Barangaroo - Crown Sydney Hotel Resort (SSD-6957-Mod-3)
Request for Additional Information

I refer to the modification application for the Barangaroo - Crown Hotel Resort (SSD-6957-Mod-3). After careful consideration, the Department is requesting that you provide additional information.

Planning Modification Floor Plan Level 48

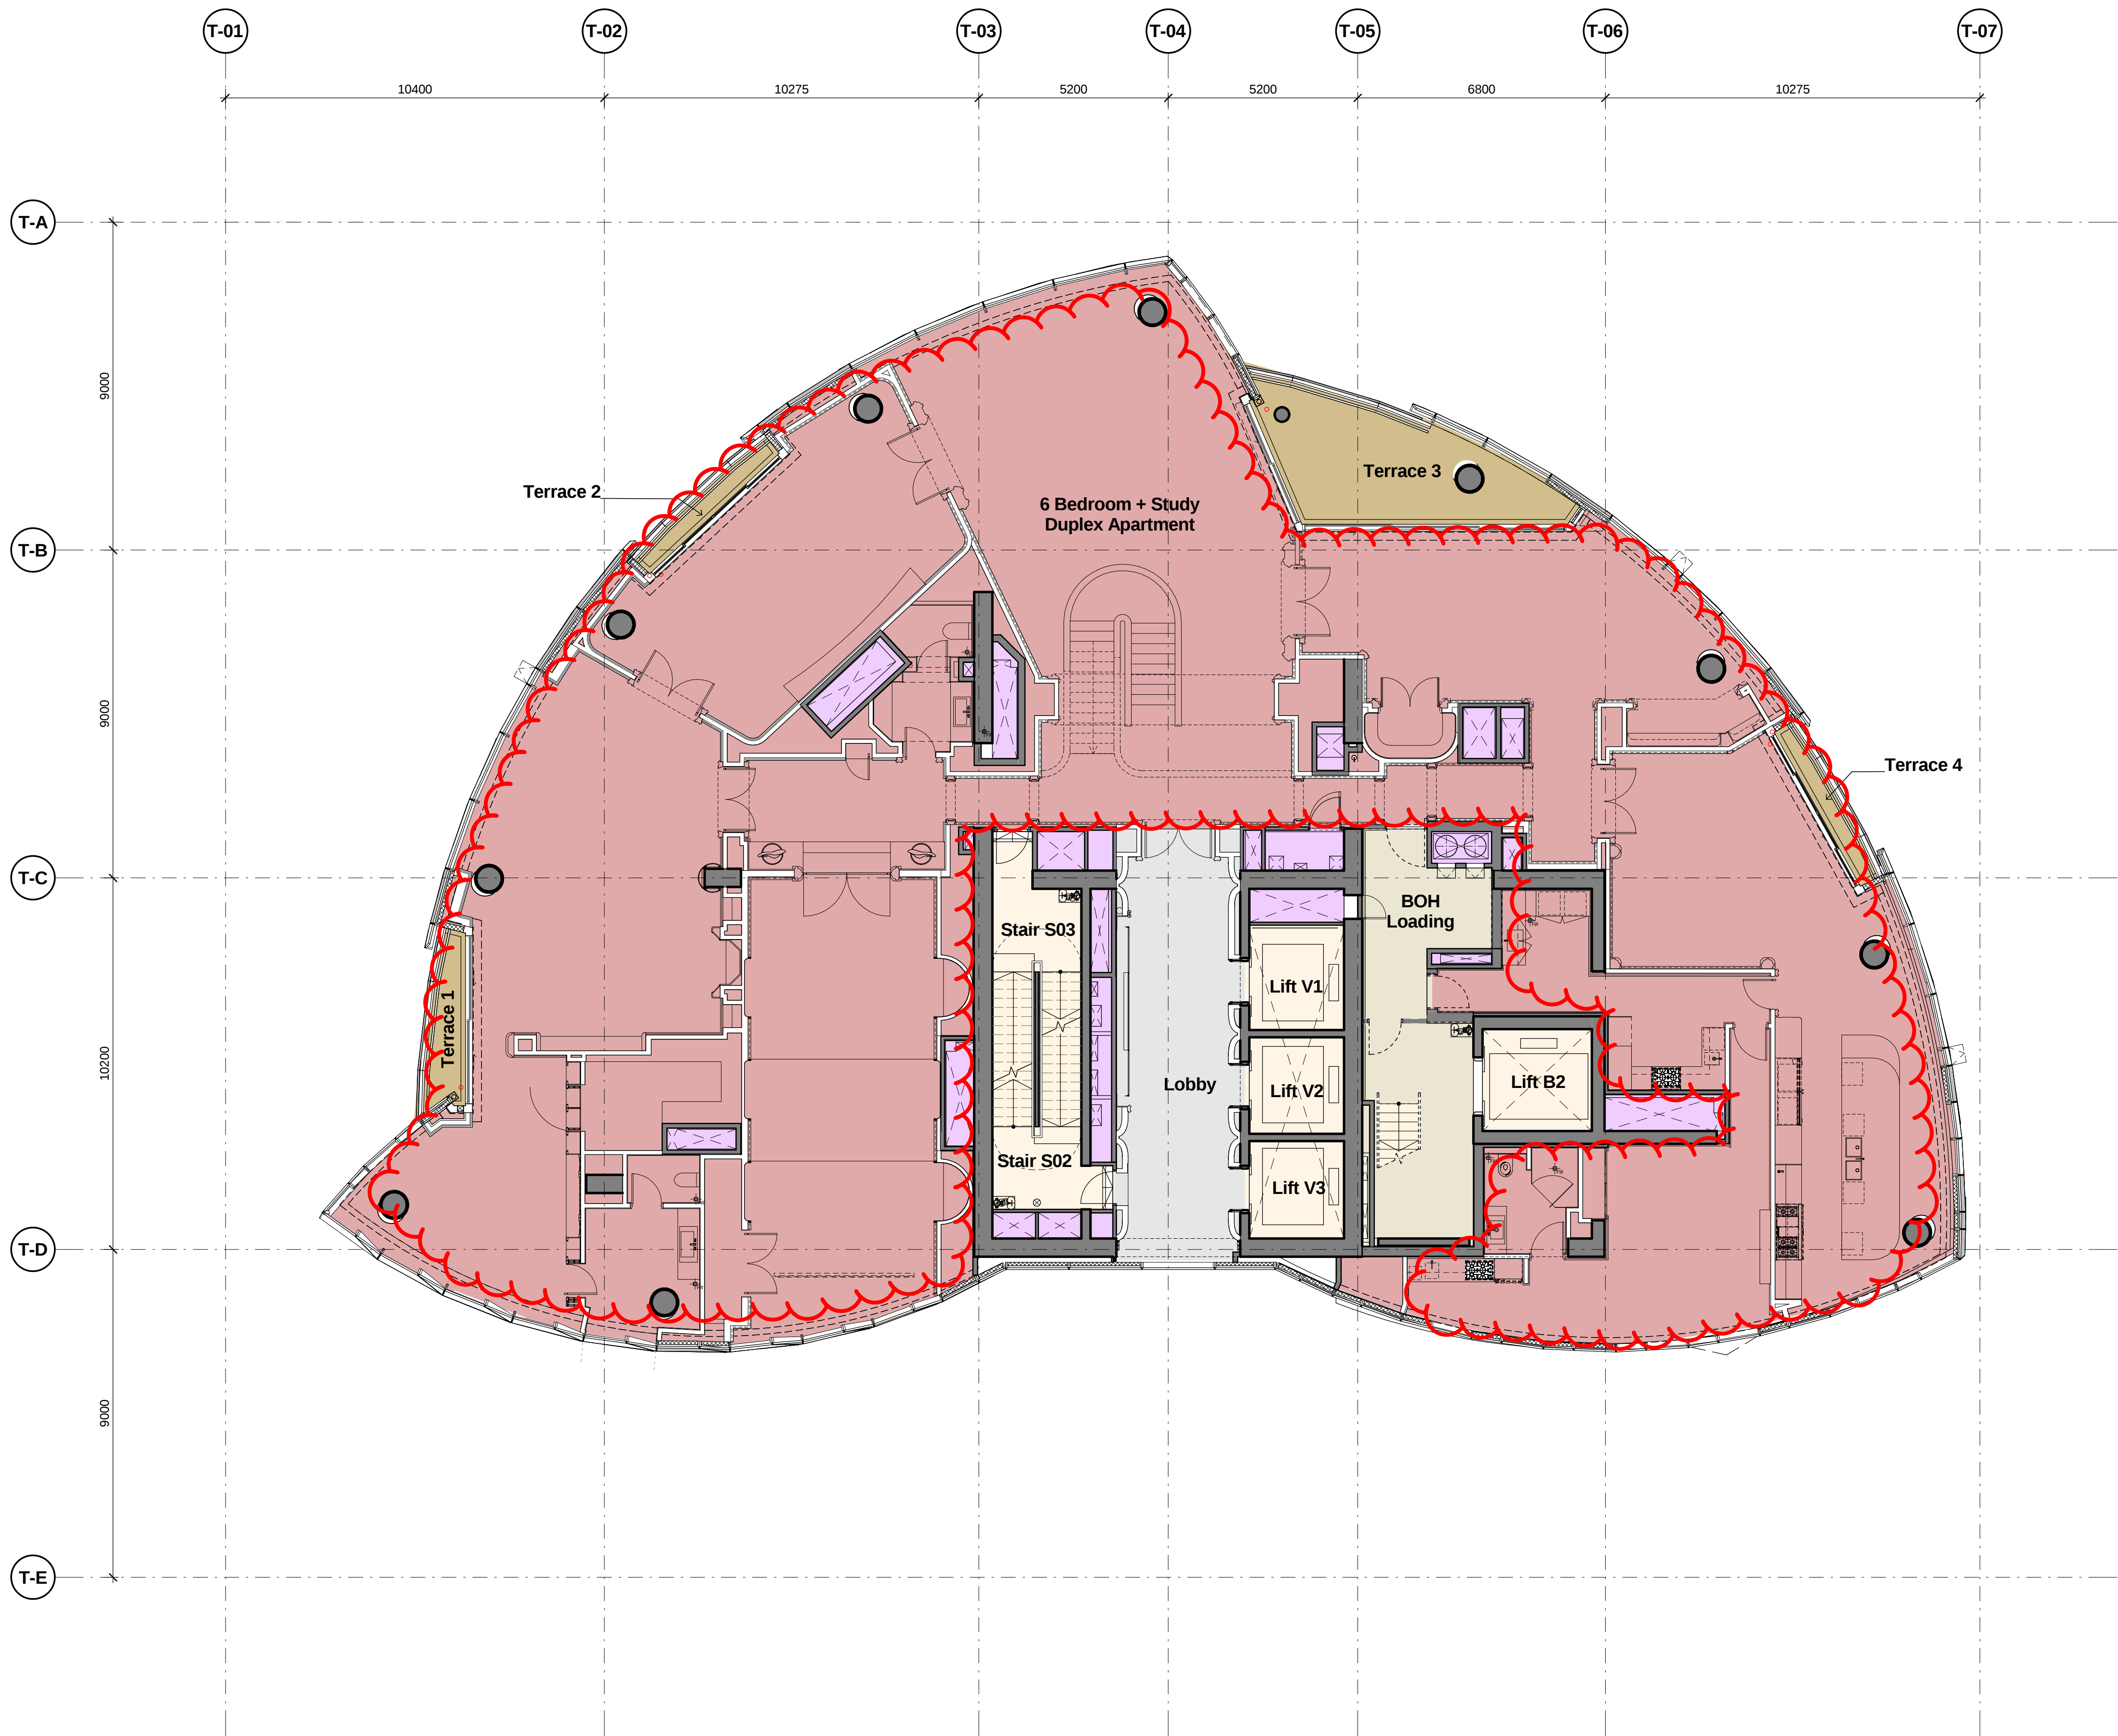
The Department notes the ADG assessment submitted as Appendix B provides an assessment of the overall approved and proposed apartments. However, the ADG assessment should also specifically consider the new amalgamated apartment on levels 48 and 49 against the relevant apartment specific objectives in the ADG e.g. ceiling height, apartment size etc.
